From: Thomas Callaway
Sent: 23 March 2017 16:03
To: Planning.Responses
Subject: RE: Planning Consultation on: EG/14/17/HH

NOTIFICATION FROM ARUN DISTRICT COUNCIL
Town & Country Planning Act 1990 (as amended)
Town & country Planning (Development Management Procedure) (England) Order 2015
Planning Permission for Works or Extension to a Dwelling
APPLICATION EG/14/17/HH

Site Address: Wanley Lodge Wandleys Lane Fontwell Eastergate PO20 3SE

Description of Works: New demountable steel framed canopy for historic vehicle,
3.5m wide x 7.0m long x 3.2m high

EXISTING ROOF PLAN
PROPOSED ROOF PLAN
ROOF PLANS 1:250

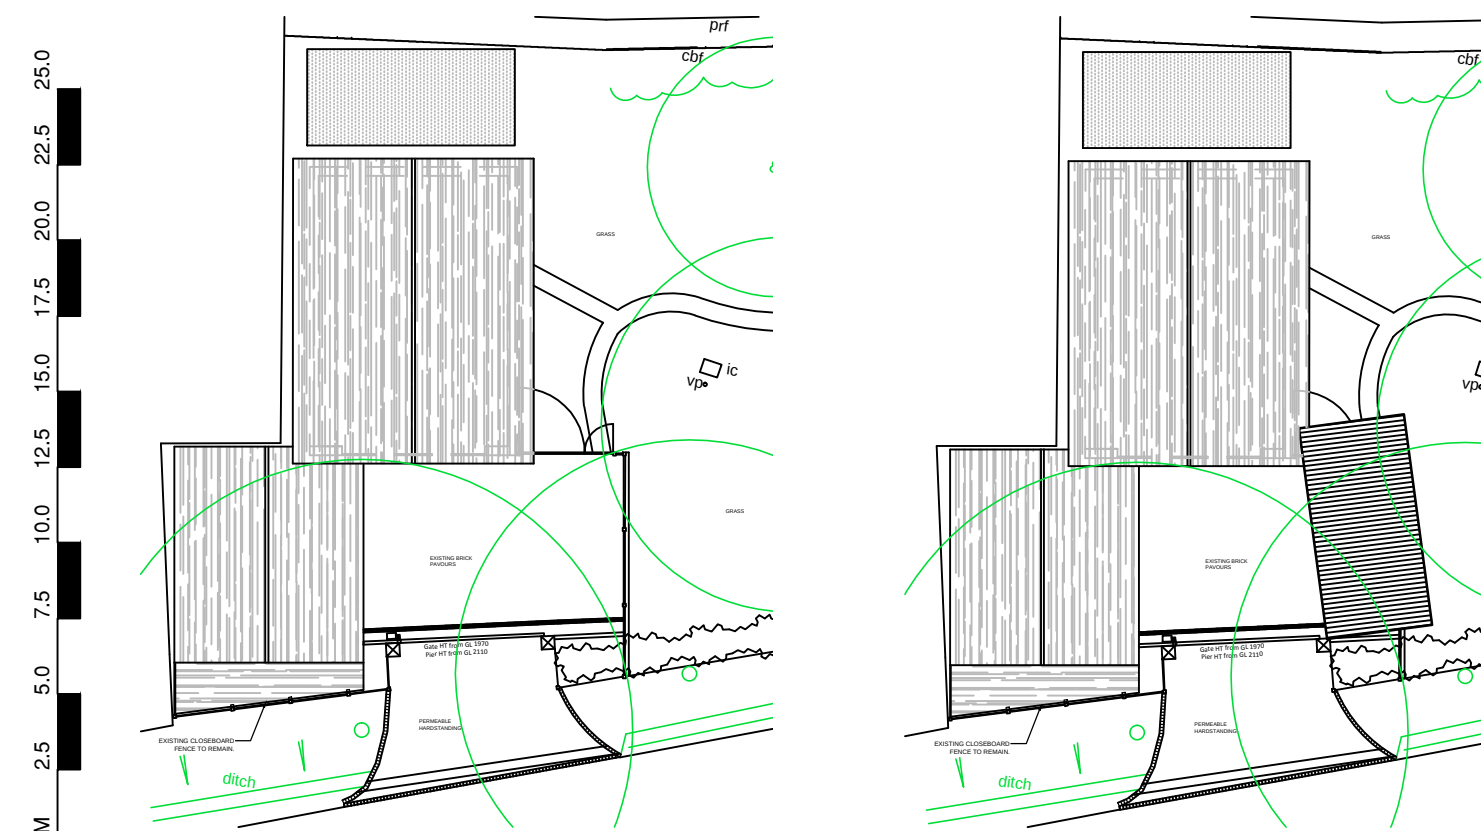
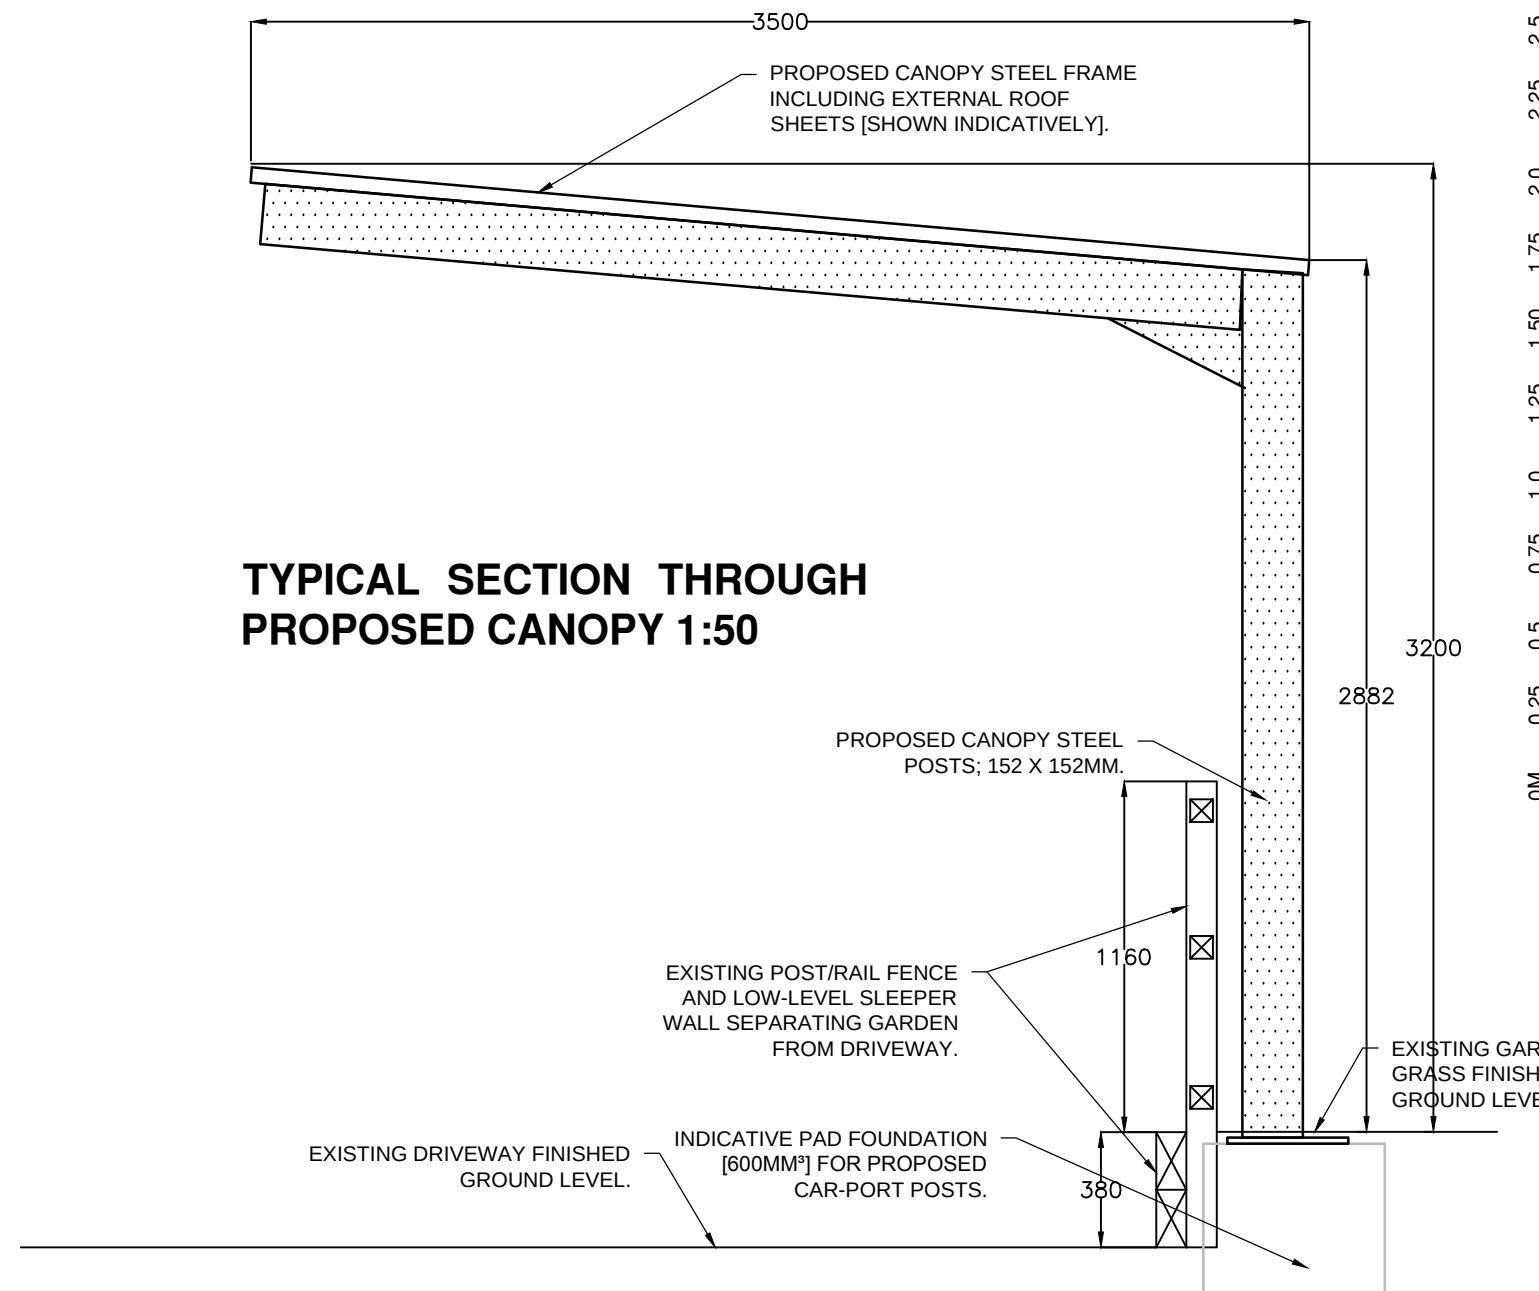
It would be worth considering guttering and some form of surface water drainage for the structure. This could be a small soakaway or French drain or similar.
